Consultation Response from KC Highways Development Management

2026/90562 35 Edge Avenue, Thornhill, Dewsbury, WF12 0EL

Demolition of existing side extension and outbuilding and erection of two storey side extension

Responding Ref: K16-18SE/18

Issue Purpose : HH Application	
Project	Proposed double storey side extension
Date	24-02-2026
Scale	1:250 @ A3
Address	35 Edge Avenue, Dewsbury, WF12 0EL
Site Plans	
D.N.	2611 - 35EA - 02

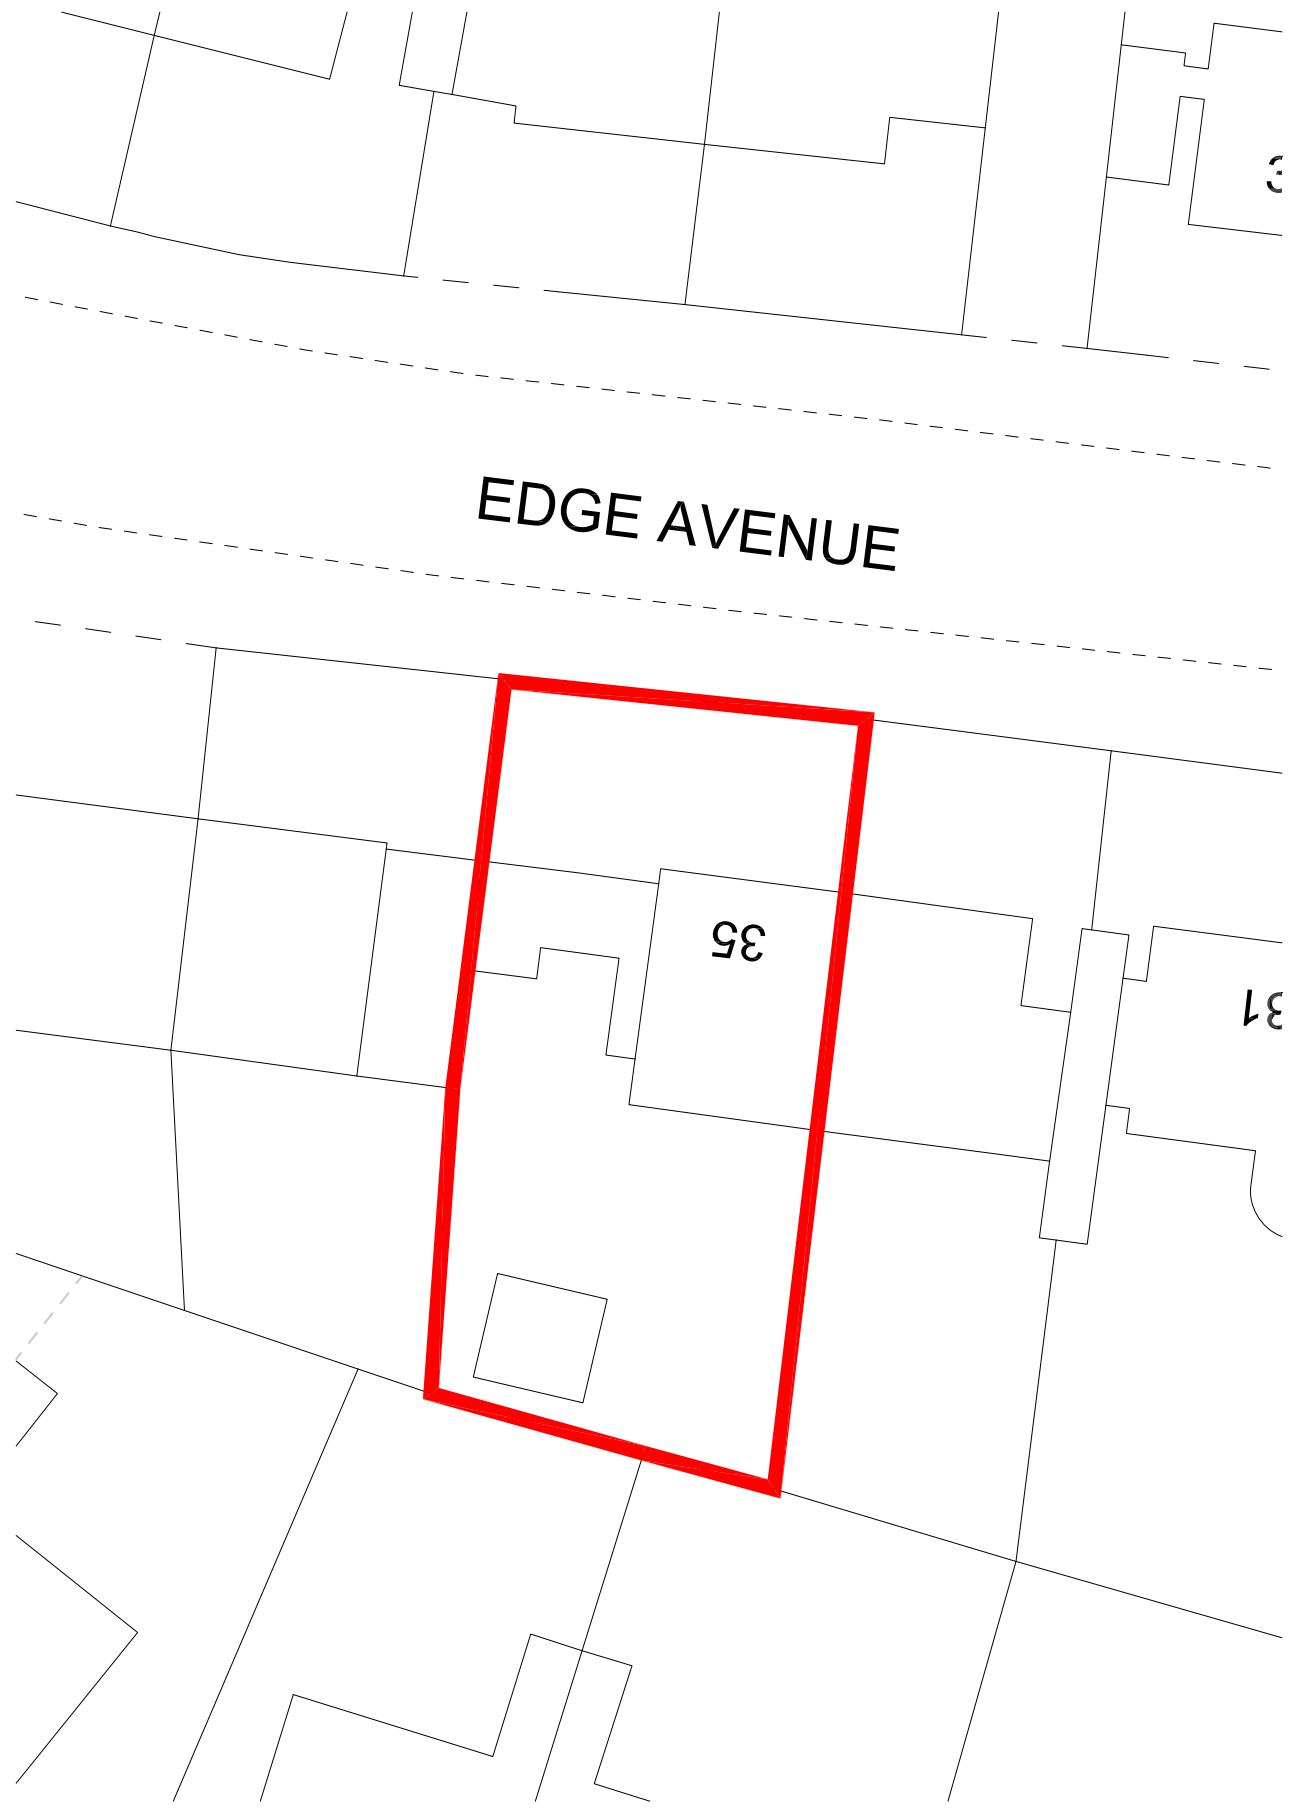
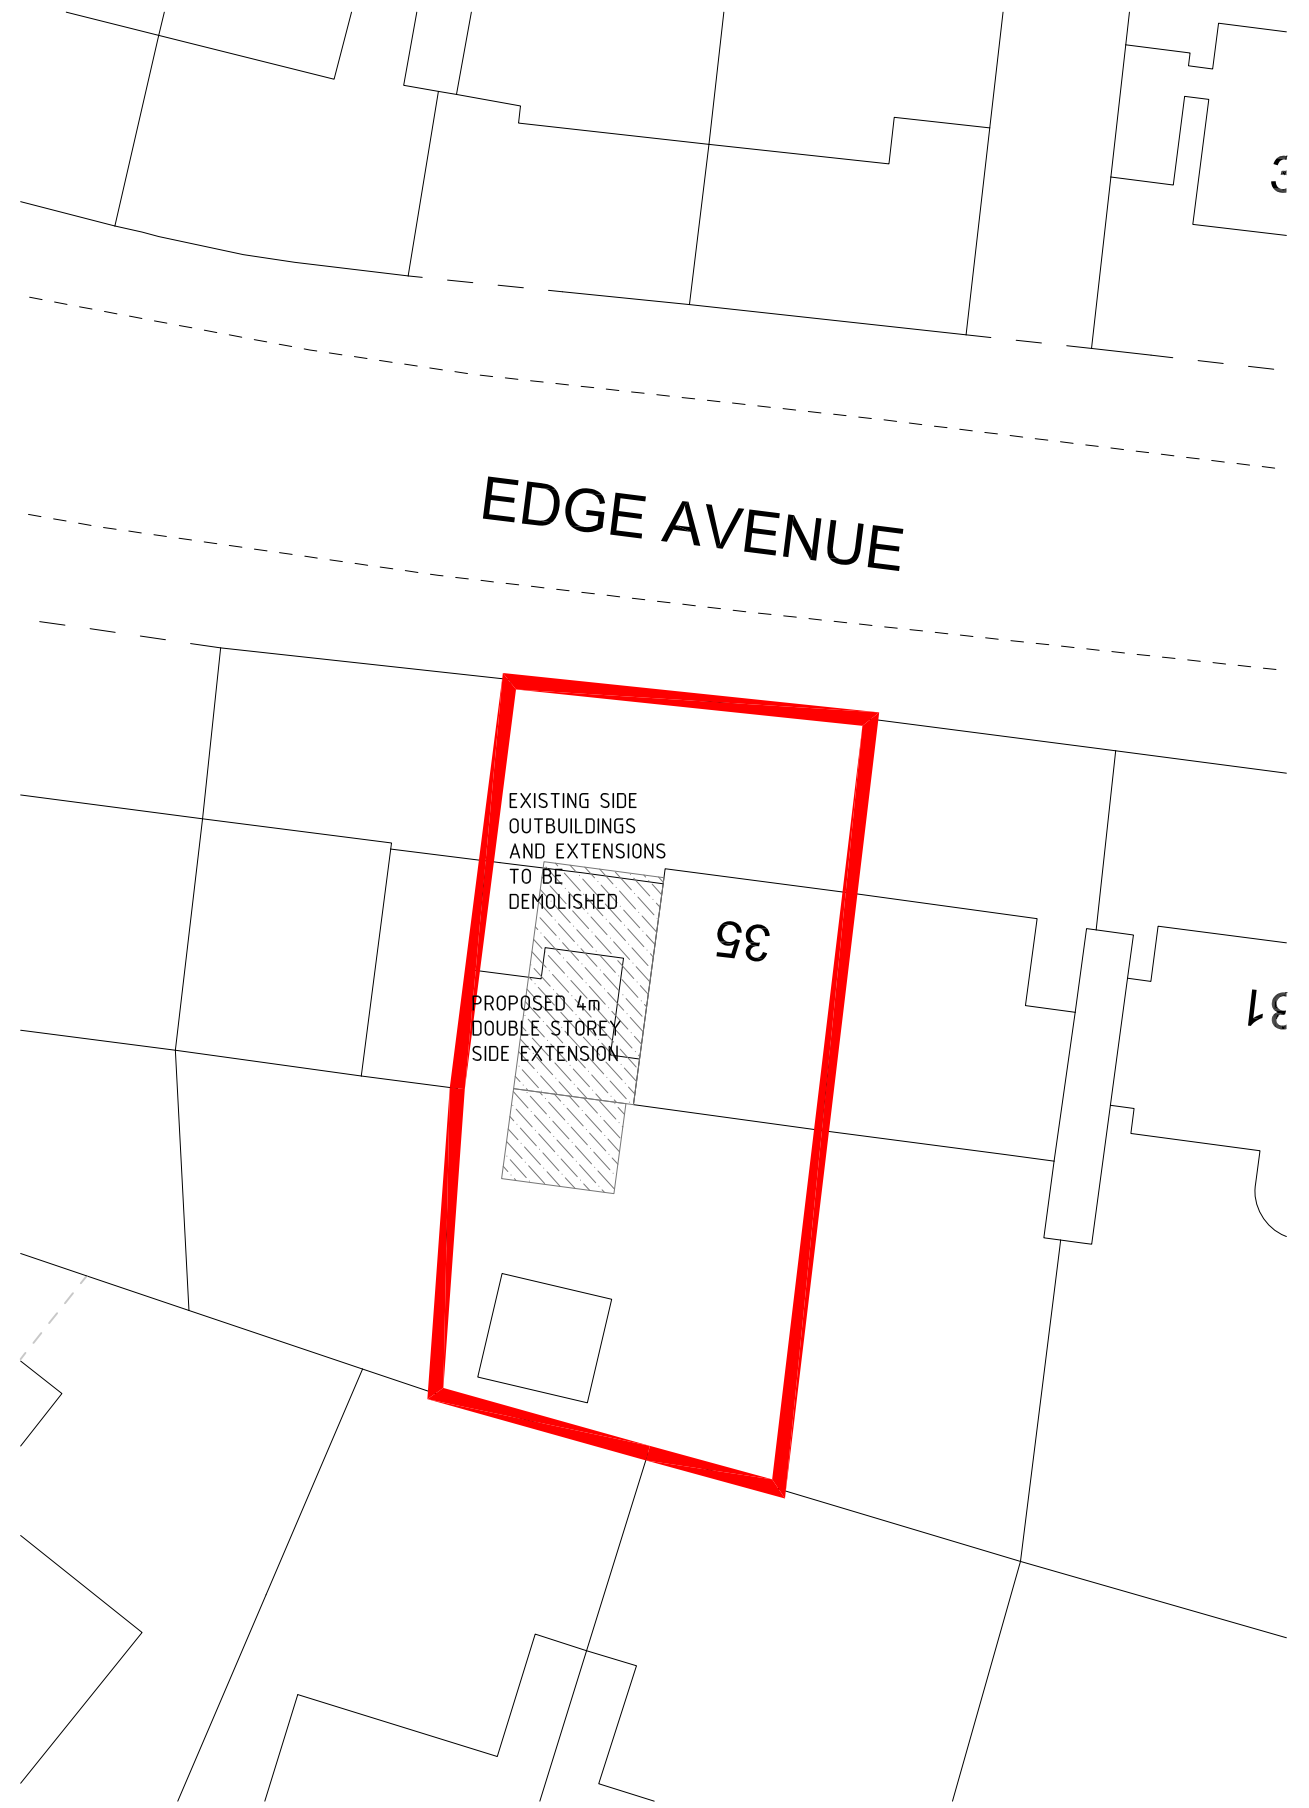
The current arrangements provide a single driveway on the property frontage which has metal gates on the boundary. The proposed side extension appears to bring the building line forward slightly to reduce the length of the driveway to approximately 5.8m which should still be adequate to park a car.

At present there is a single vehicular access along the site boundary that provides access for one parking space. The proposed side extension appears to bring the building line forward slightly to reduce the length of the driveway to approximately 5.8m which should still be adequate to park a single vehicle.

At present the proposed arrangements fall short of the parking standards outlined in the Kirklees Highway Design Guide and the LHA would recommend that additional parking is provided within the site to ensure there are two off street parking spaces provided.

The LHA considers that a driveway for two car parking spaces is deliverable on the site and should be secured.

The Kirklees Highway Design Guide states that any parking surface located immediately in front of a property should be permeable, bonded/ interlocking and preferably finished with a natural material.

Furthermore, before it can be constructed, the parking area / driveway must have a way of preventing surface water from flowing onto the public highway to comply with Section 163 of the Highways Act 1980.

Whilst the kerbing along the site frontage appears relatively low, an amended / widened vehicular access to the property may need to be secured from Kirklees Council in accordance with Section 184 of the Highways Act 1980. Full details of the application process are detailed here: [Dropped kerbs | Kirklees Council](#)

RECOMMENDATION: No objection in principle subject to the provision of an additional parking space within the site.

Conclusion: No objection to the proposals in principle subject to the provision of an additional parking space within the site and compliance with Kirklees Dropped Kerbs guidance. Should the provision of an extended dropped kerb be required a Section 184 application to Kirklees Council would need to be undertaken.
